Recommendation Report for Planning Permission for Works or Extension to a Dwelling

REF NO: M/30/19/HH

LOCATION: 11 Penn Close
Middleton on Sea
PO22 7SG

PROPOSAL: Single storey rear extension

19/4617/3

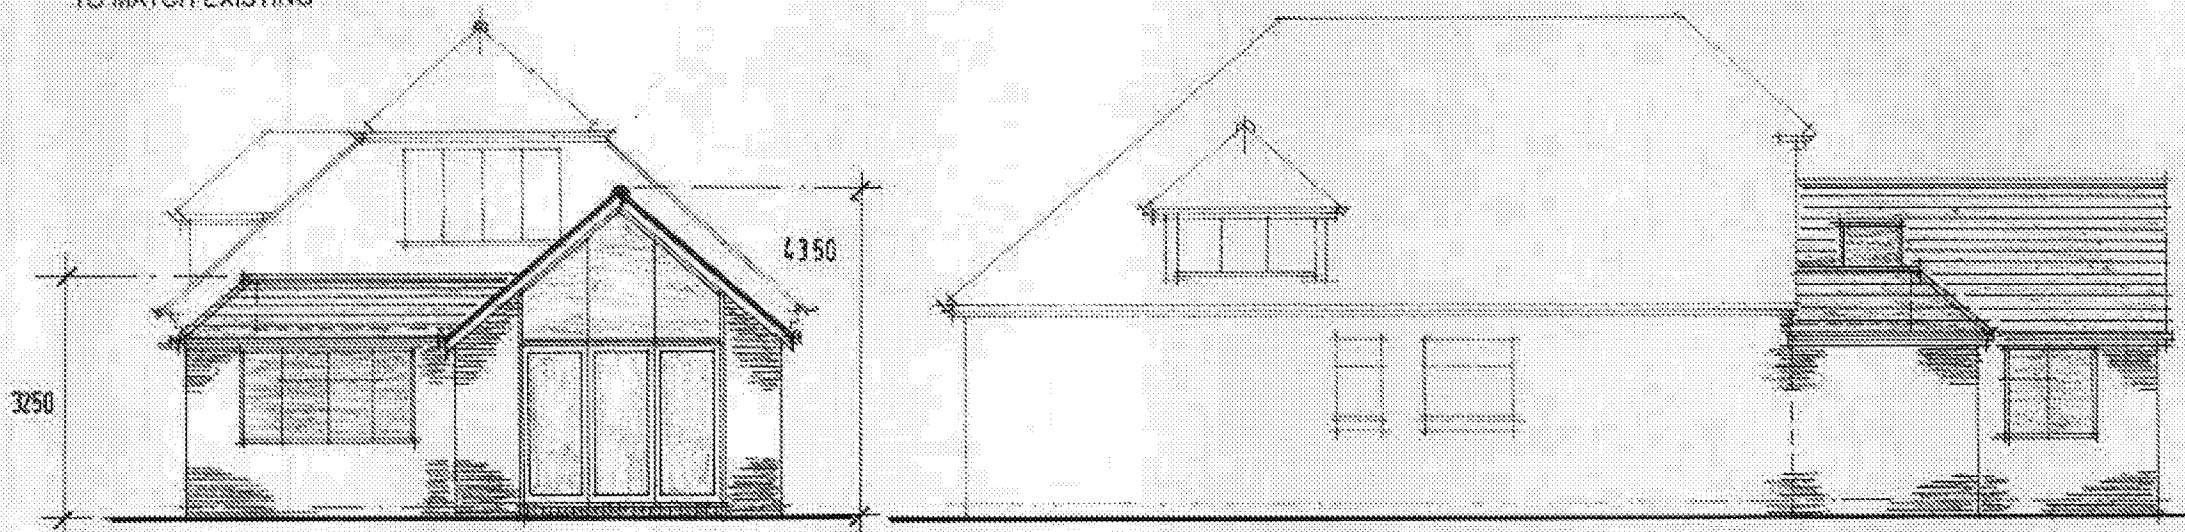
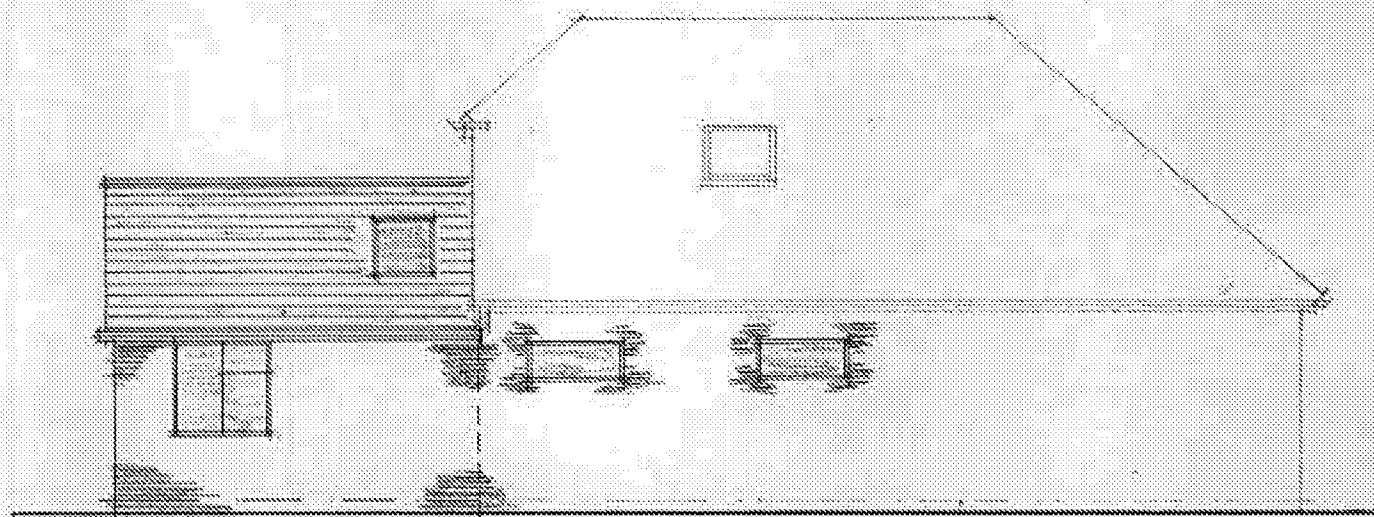
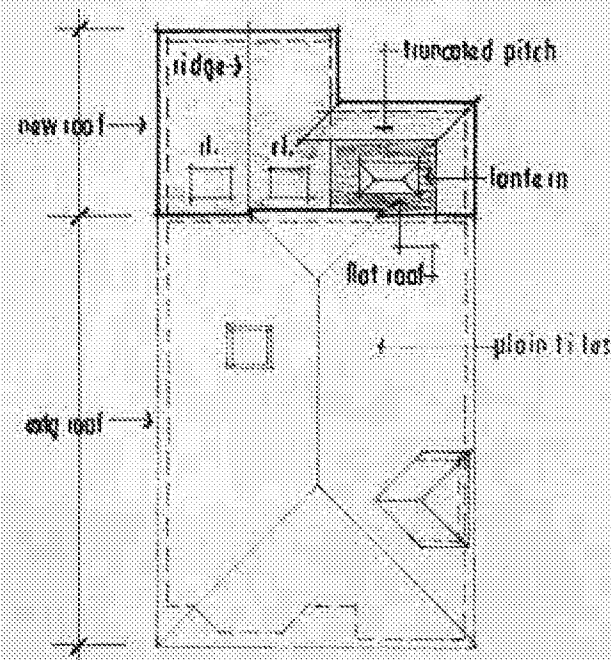
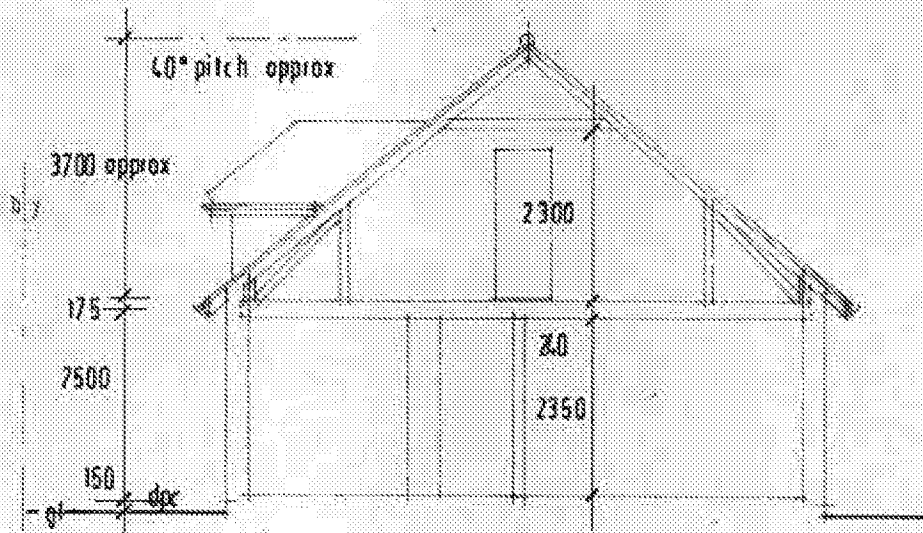
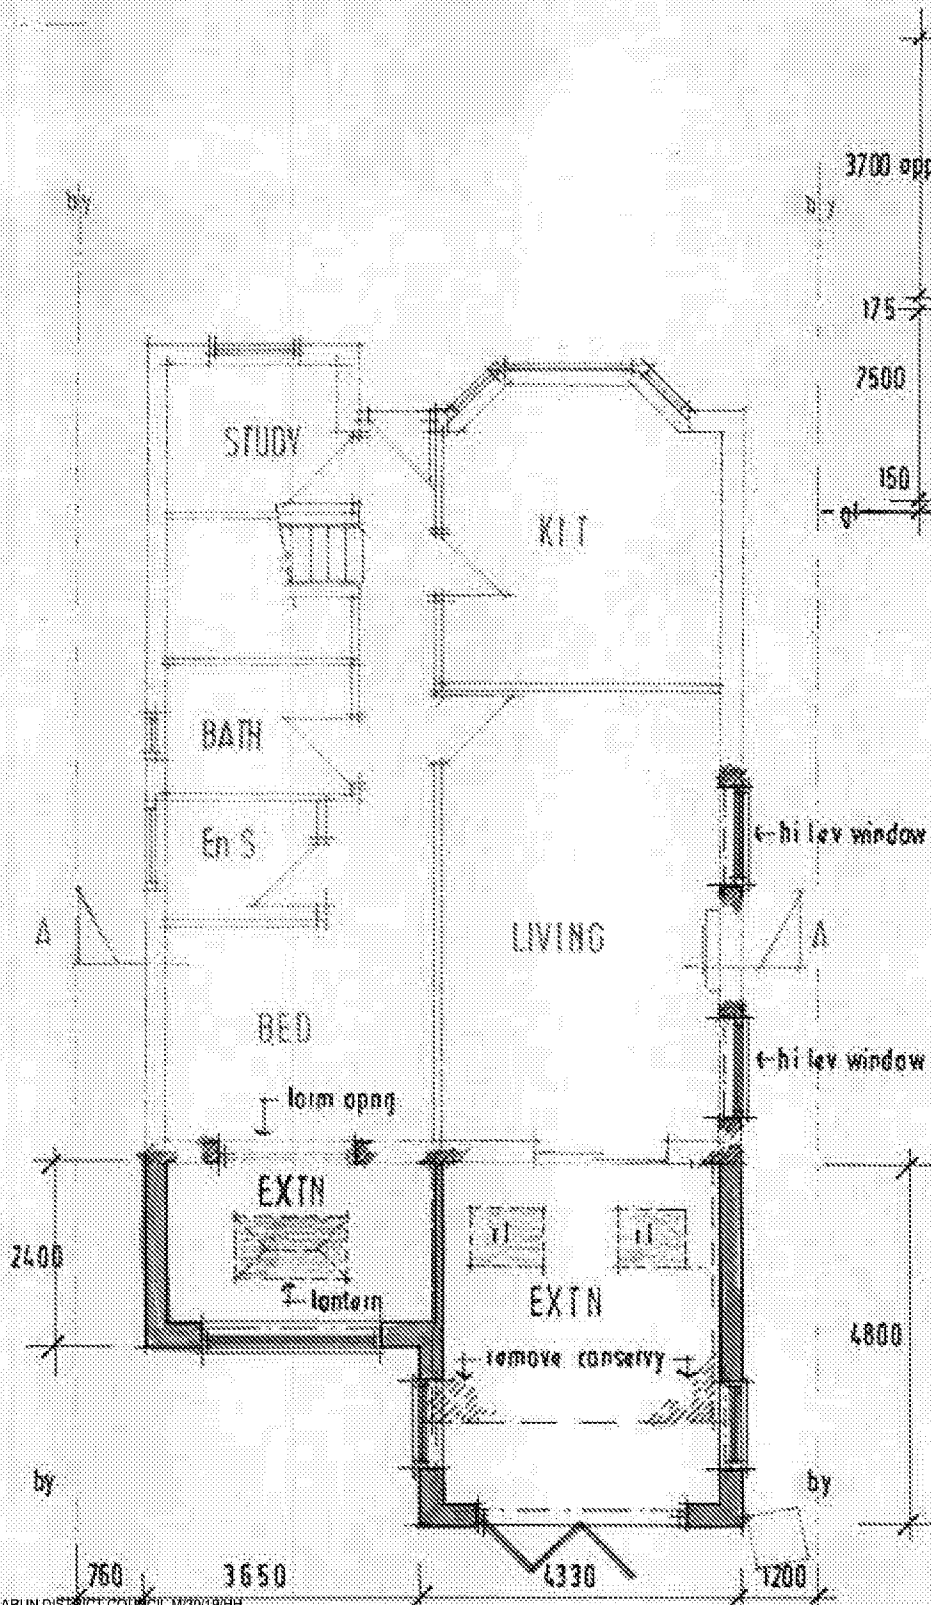
The proposed development is not visible from the street scene, and as a result, is not considered to have any significant impact upon the street scene, and resultantly, the character of the area. As a result of the scale of the proposal, use of materials, and roof slope angle, it is considered to be a subservient addition to the host dwelling. Therefore, the proposed development is considered to be in accordance with D DM1, D DM4(a) and (b) of the Arun Local Plan.

The height of the Eastern element of the proposed rear extension is noted, as it reaches a maximum height of 4.3m maximum height. However, this height slopes down to an eaves height of 2.4m, when 1.2m from the sites Eastern boundary. Therefore, the ridge height of the proposal is approximately 3.4m from the Eastern boundary of the application site, which is considered to mitigate any significant overbearing or overshadowing impact on the adjacent occupiers to the East. It is noted that the proposed development introduces new windows into the host dwelling, however, these are at ground floor level, and therefore, do not provide any views that are currently unavailable from the host dwelling as current. The proposed roof lantern and velux windows are at high level so do not provide views out.
